CALCULATIONS AND COMMENTS

MERCER ISLAND CENTER FOR THE ARTS CONCEPTUAL MITIGATION PLAN

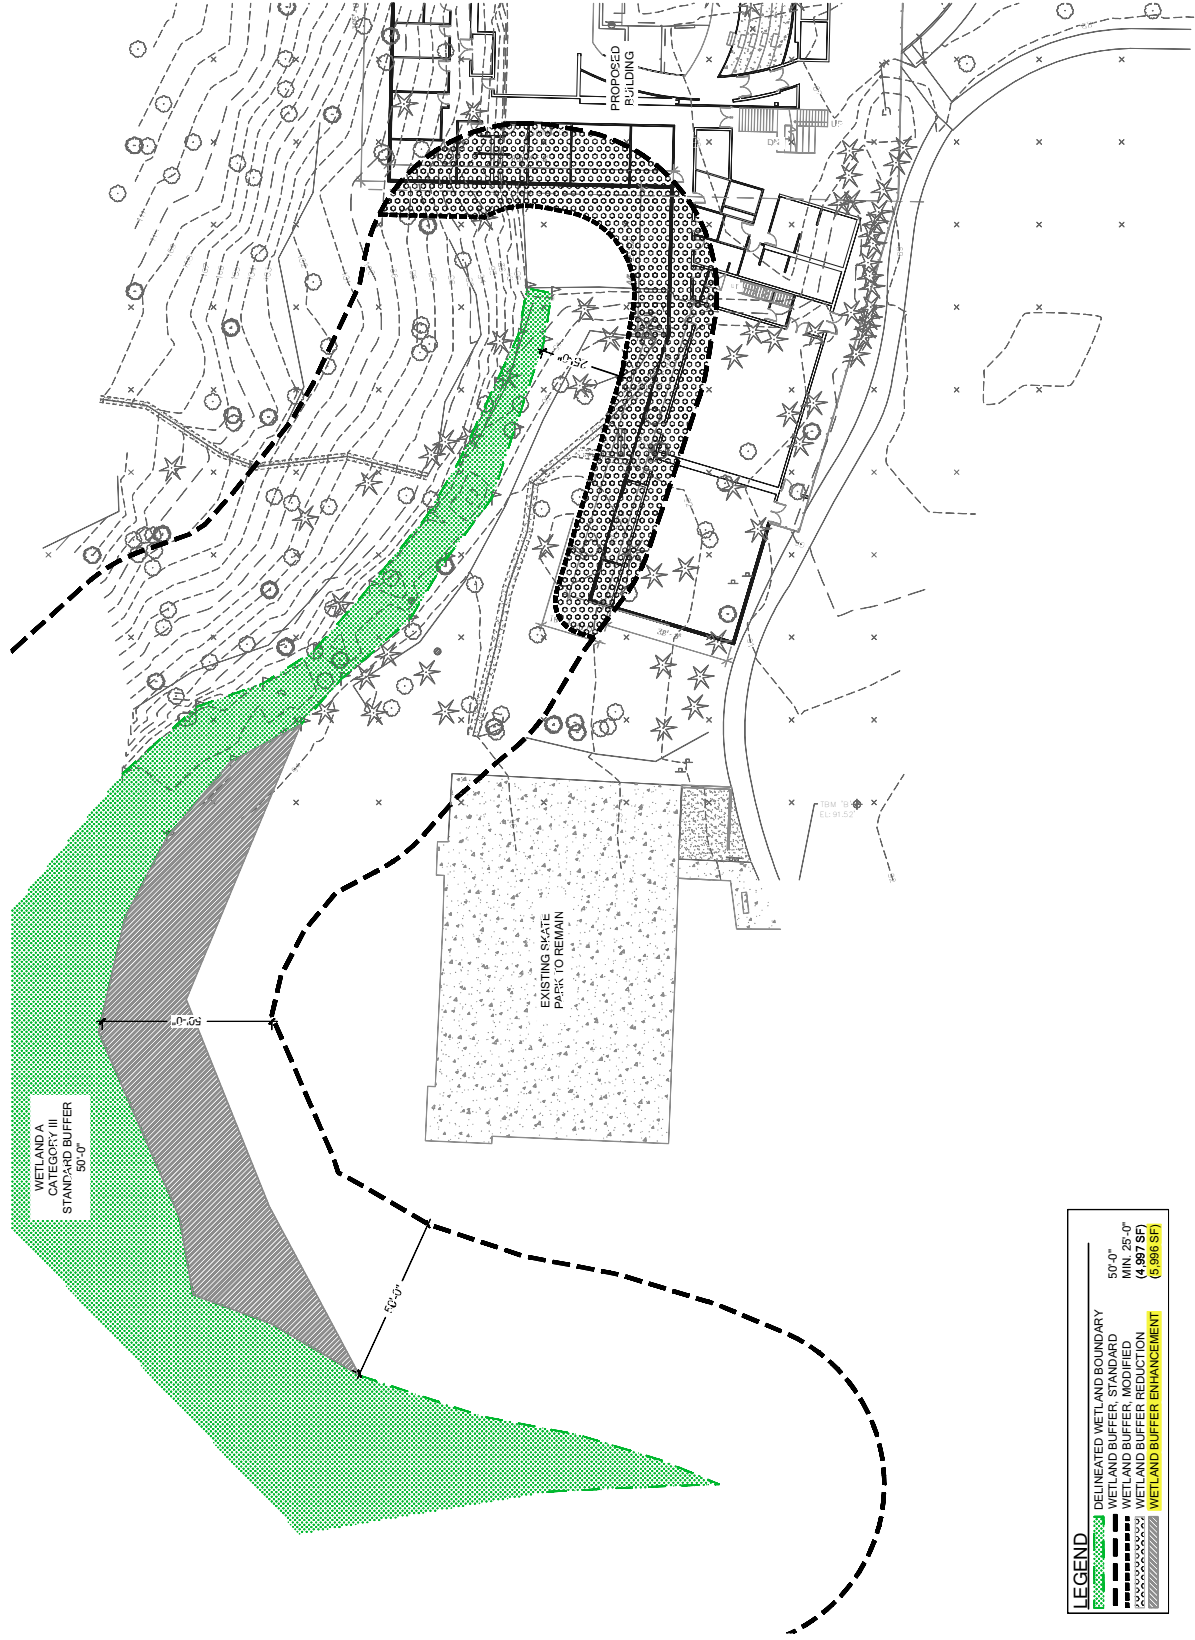
WETLAND BUFFER ENHANCEMENT = 5,996 sq. ft. = 14.2% of 42,207 sq. ft. site.

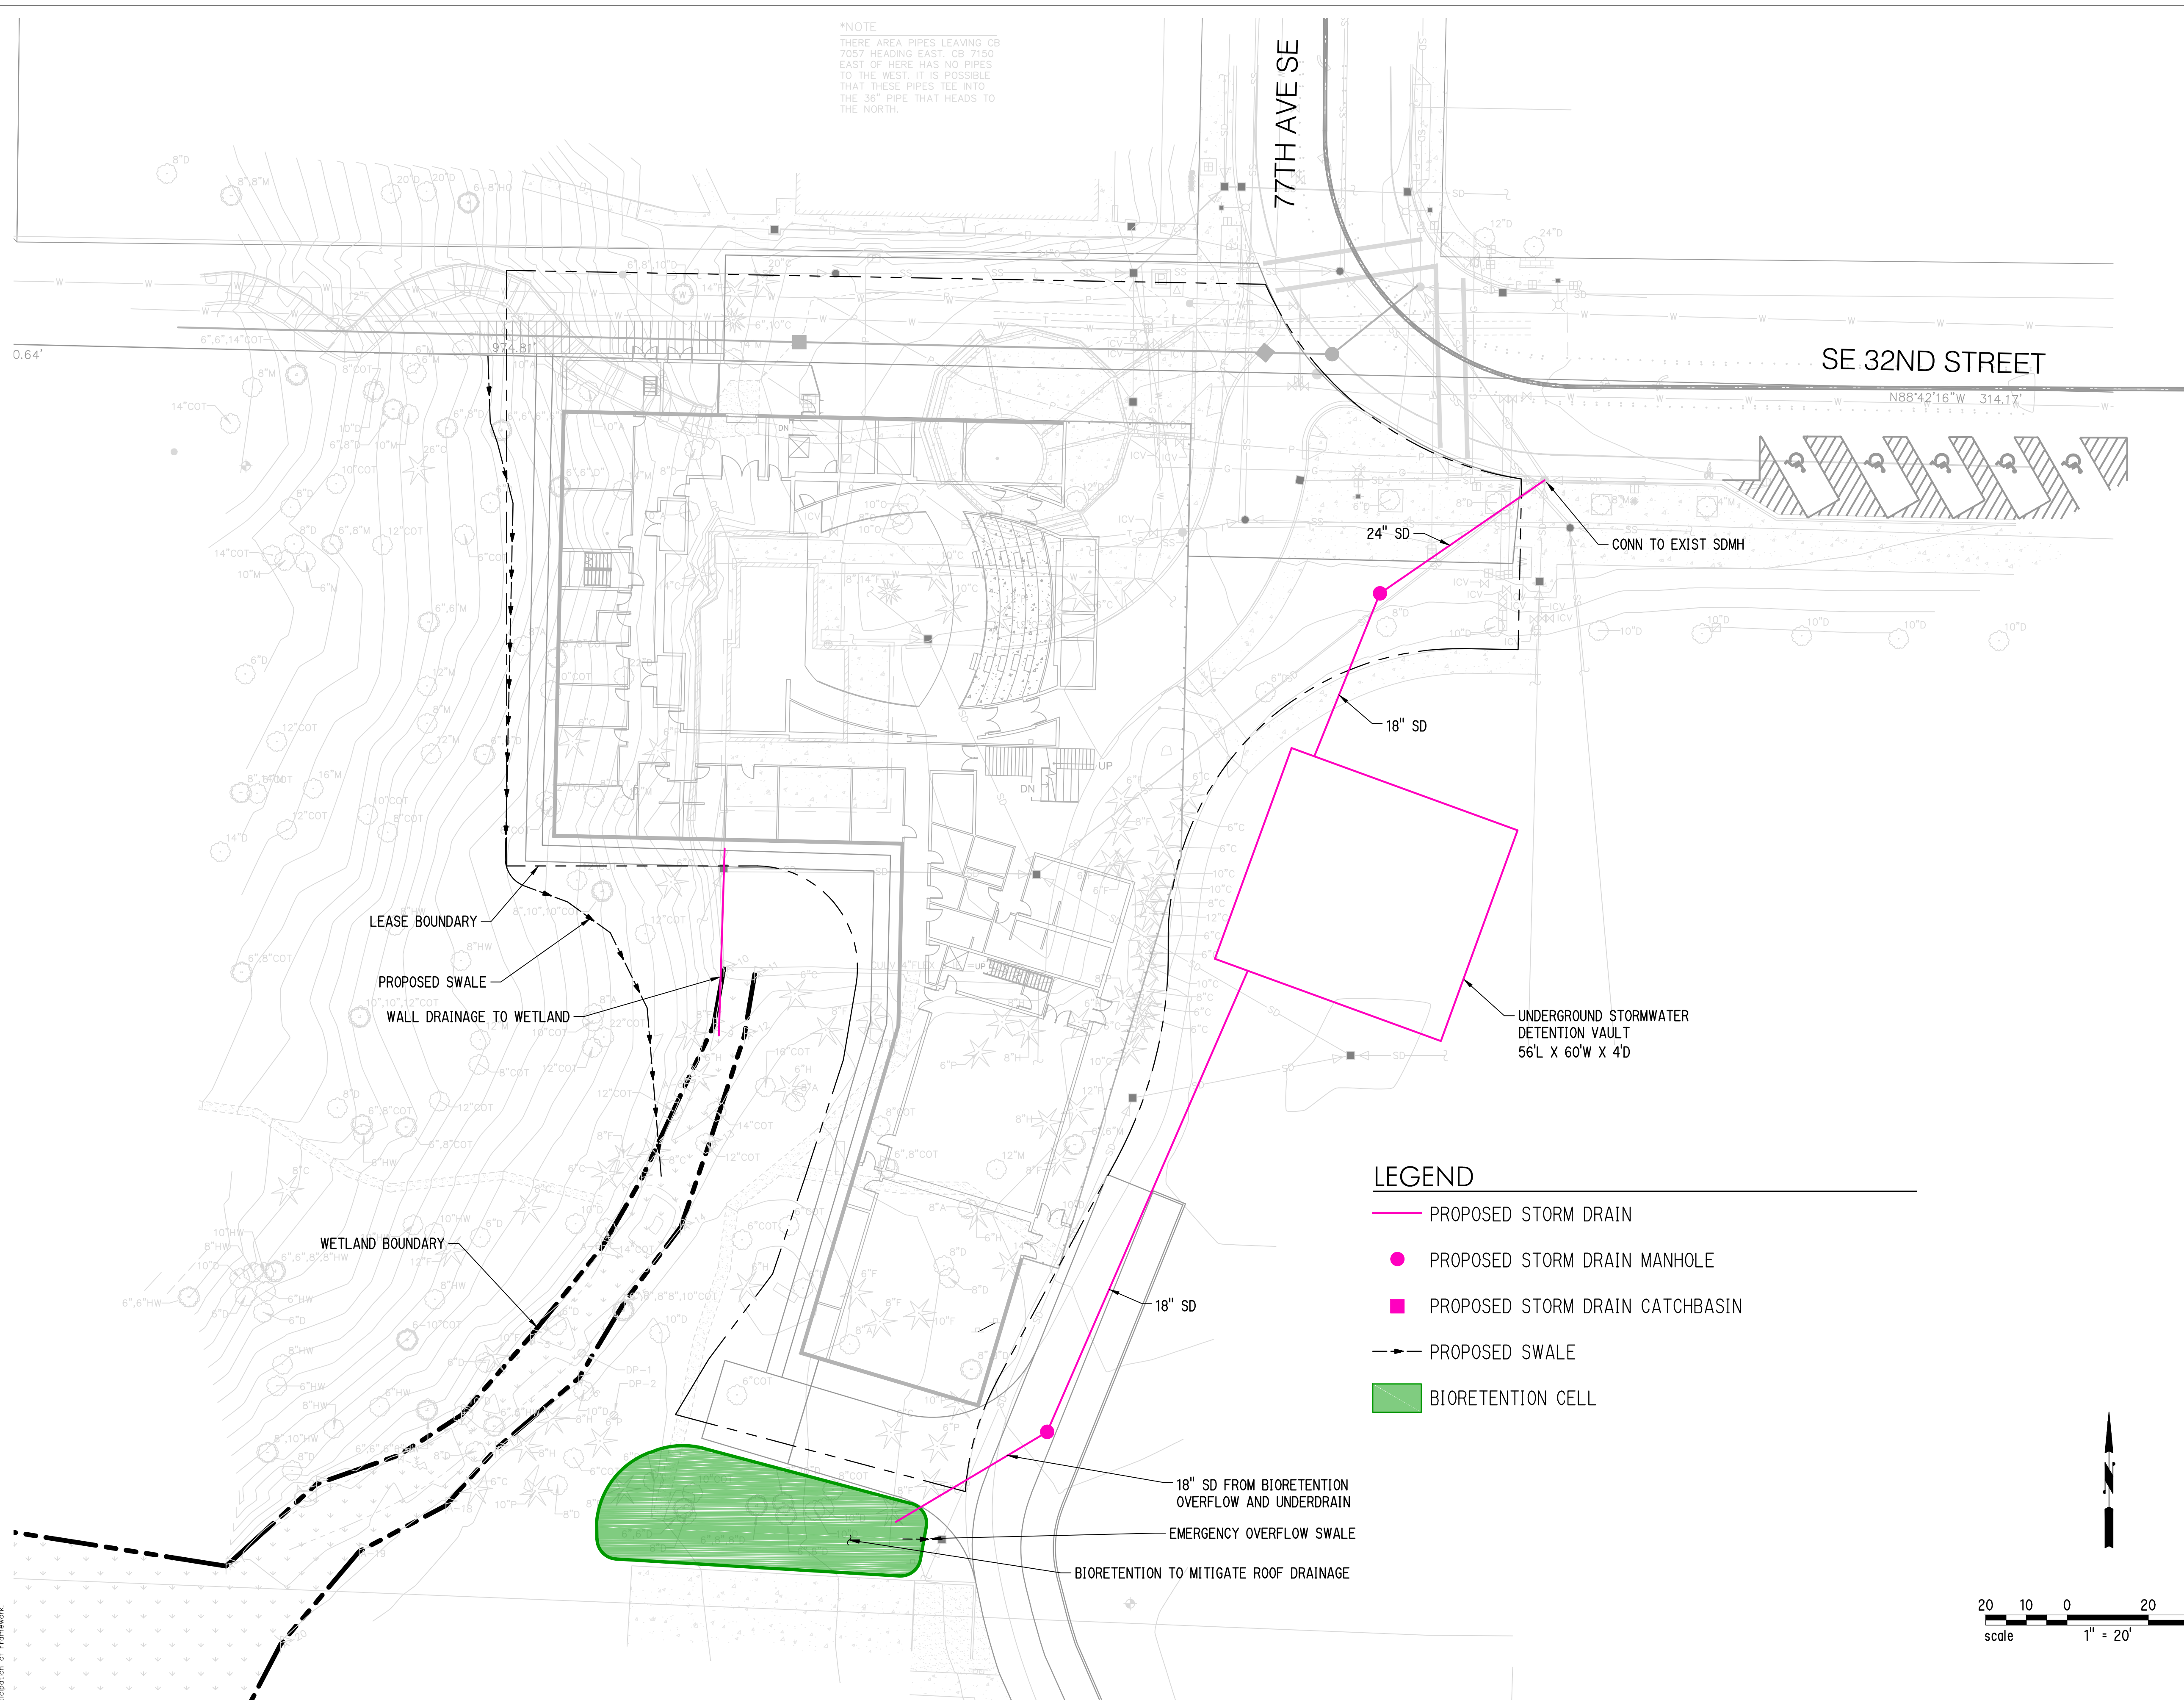
The “WALL DRAINAGE TO WETLAND” arguably is a prohibited alteration of the Mercedale Park wetland. See, e.g., Martin Law October 30, 2015, legal opinion.

The “WALL DRAINAGE TO WETLAND” arguably is a prohibited alteration of the Mercedale Park wetland buffers. See, e.g., Martin Law October 30, 2015, legal opinion.

The “PROPOSED SWALE” arguably is a prohibited alteration of the Mercedale Park wetland buffers. See, e.g., Martin Law October 30, 2015, legal opinion.
